Your Ref: OWPC6402
Our Ref: M/56/15/HH 15-05-2015
Please ask for:
Ross Leal

Side & rear extensions
31 Sea Way Middleton-on-Sea

*Application M/56/15/HH
31 Sea Way, Middleton-On-Sea, West Sussex, PO22 7RZ*

Proposed Floor Plans
- Ground Floor
- First Floor
- Roof Plan

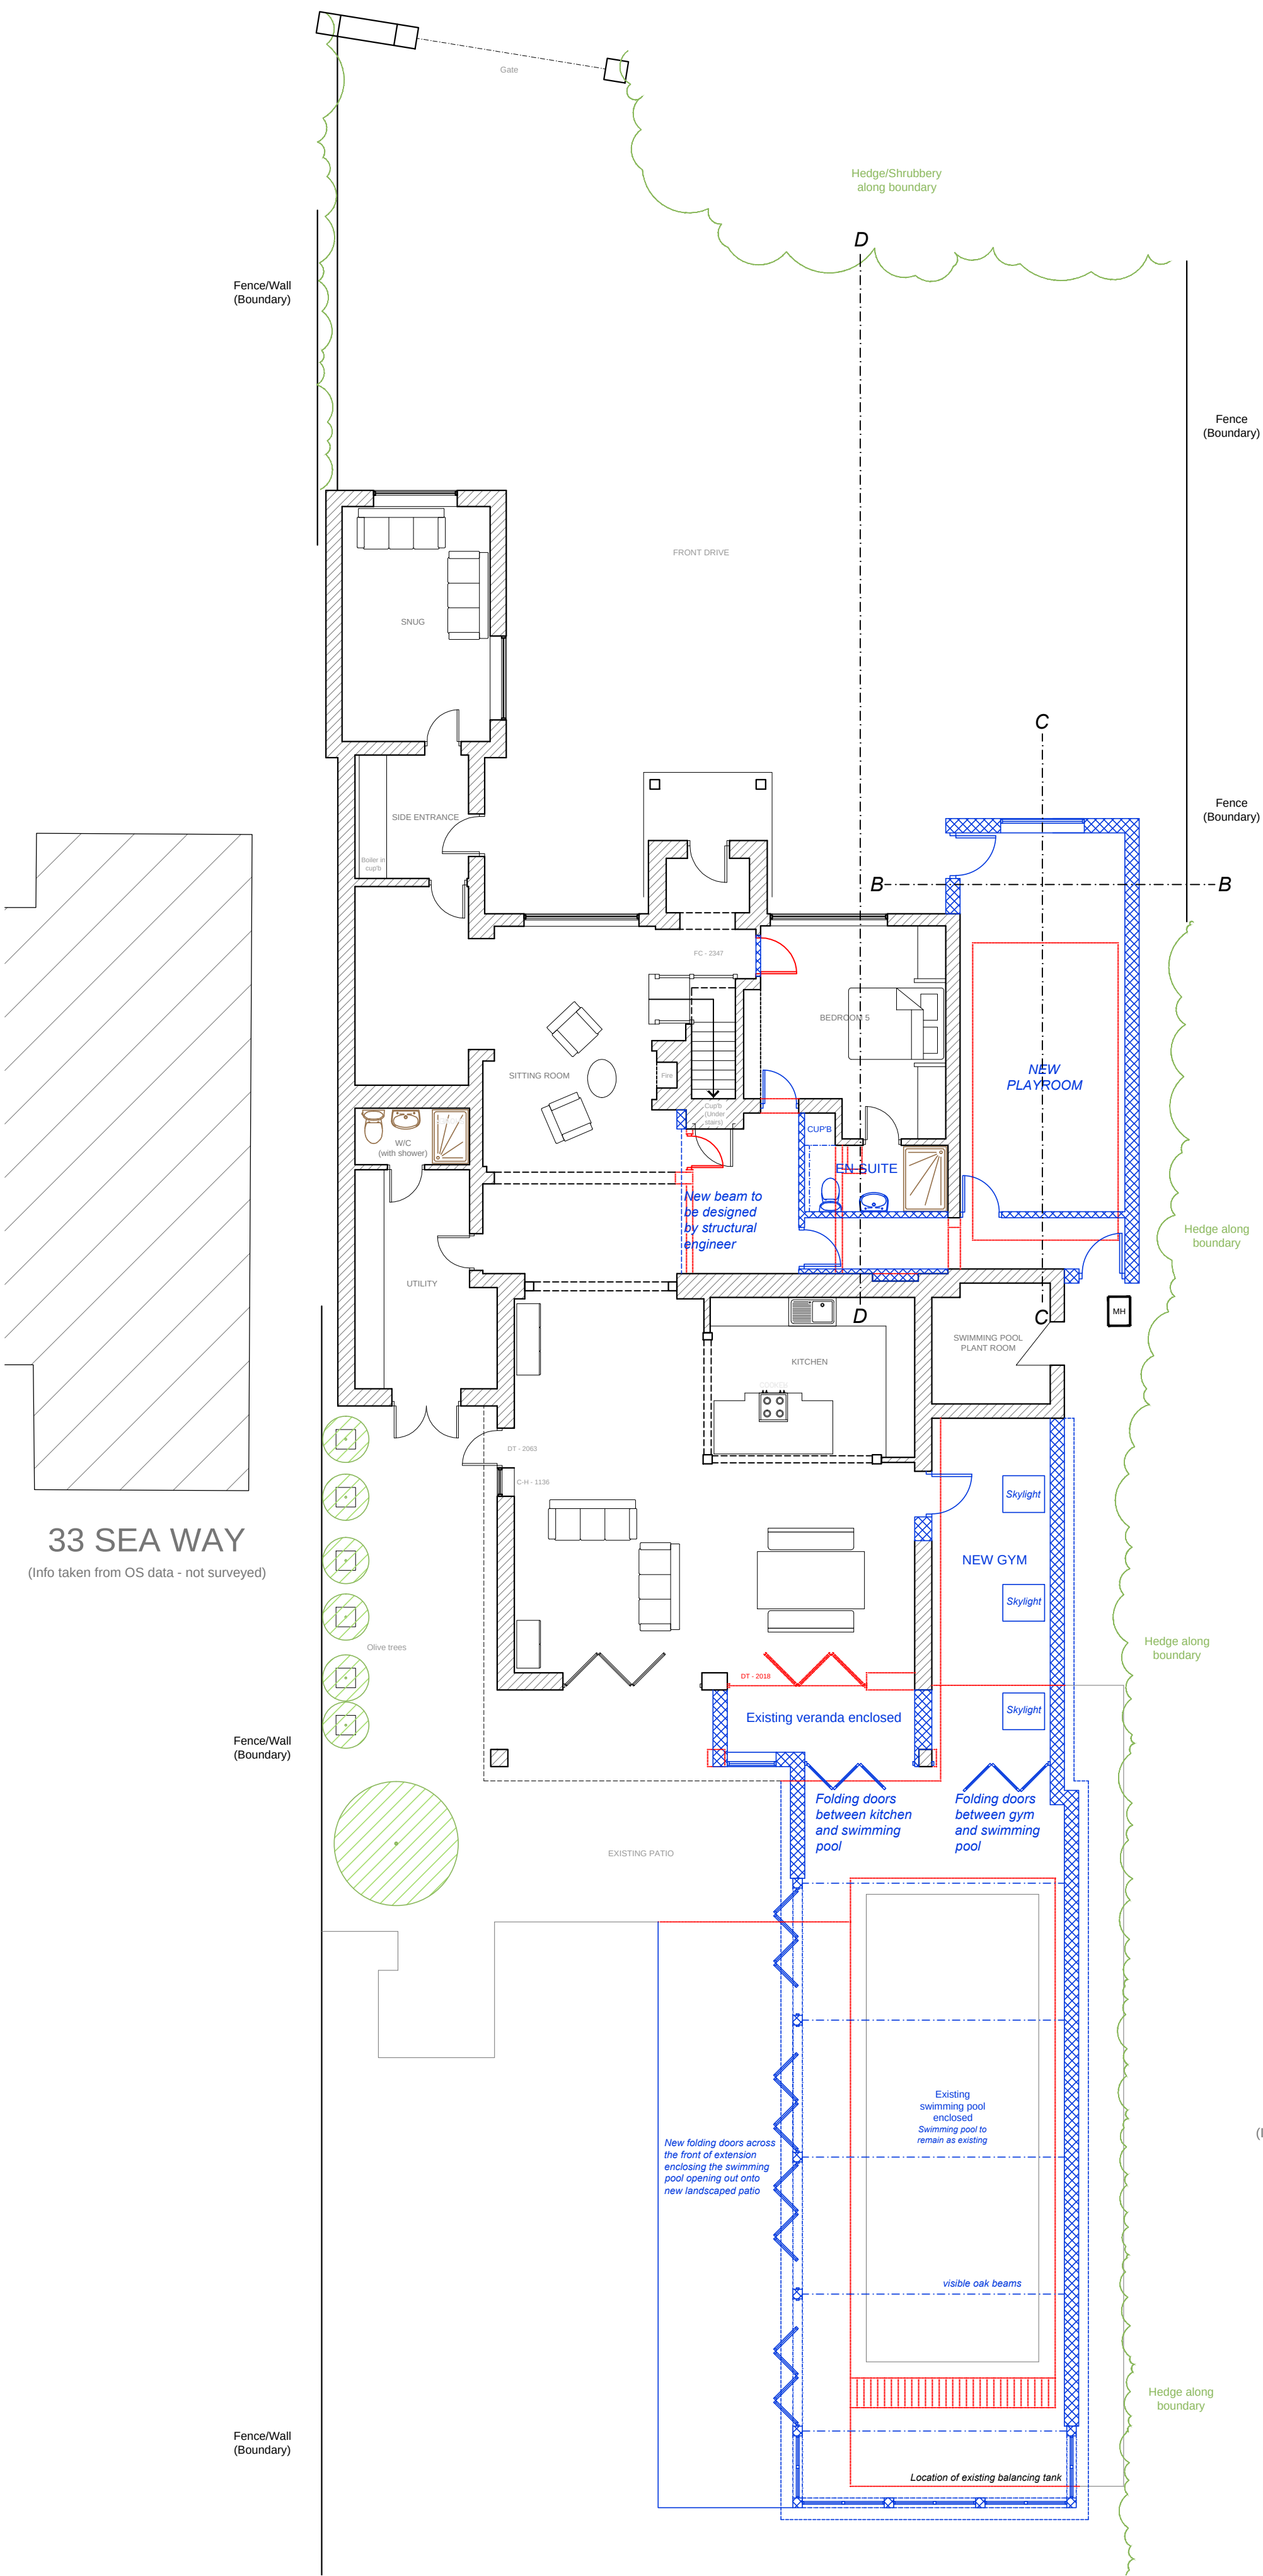
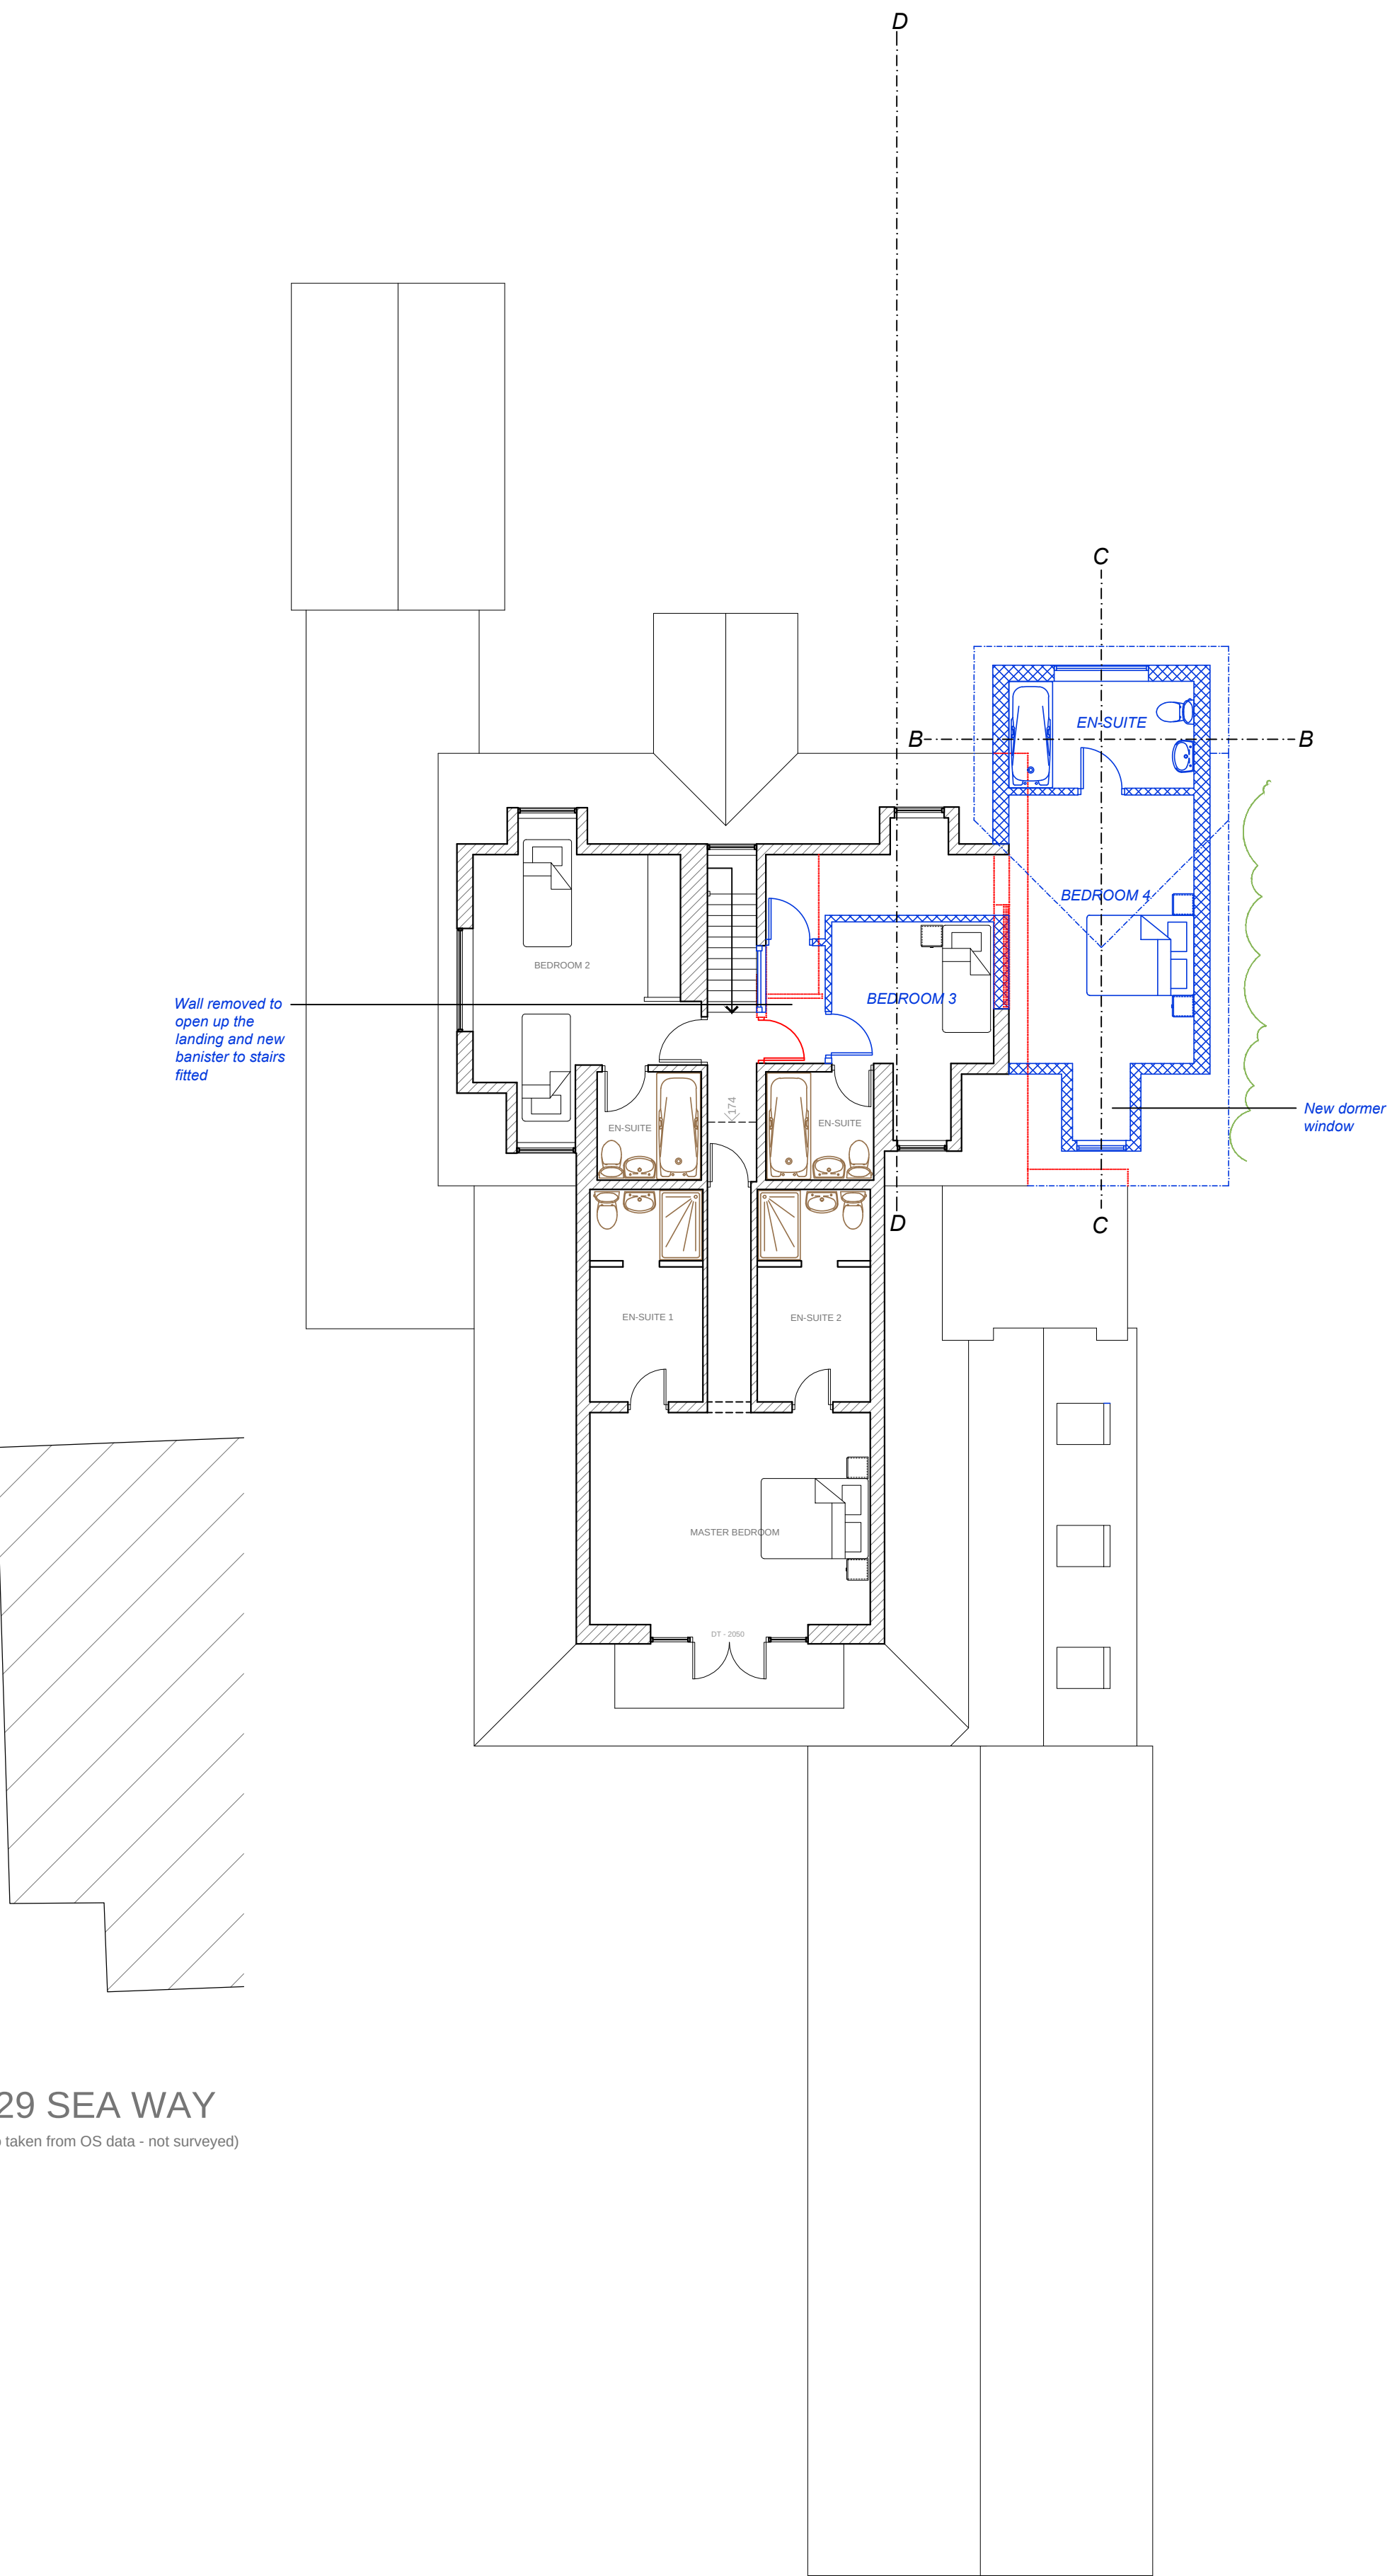
We write with reference to the amendments that have been made to the above proposal. We still feel that, even with the small reduction in height of the proposed swimming pool cover, the overall application represents a massive overdevelopment of the site. Since our first objection we have become aware of how the structure will look from upstairs at Number 29 & it simply not pleasant to inflict such a view on a neighbour. We believe it will be fully visible from the Greensward & will spoil the rural aspect from there considerably.

We believe there is an easement of 3 metres along each side of the improved drain. It would be beneficial to all concerned if a plan could be produced to show the proposed construction in relation to the drain. From the plans we have seen for the pool enclosure we believe that this 3 metre easement will be compromised. If this is the case there must be no question of planning permission being granted.
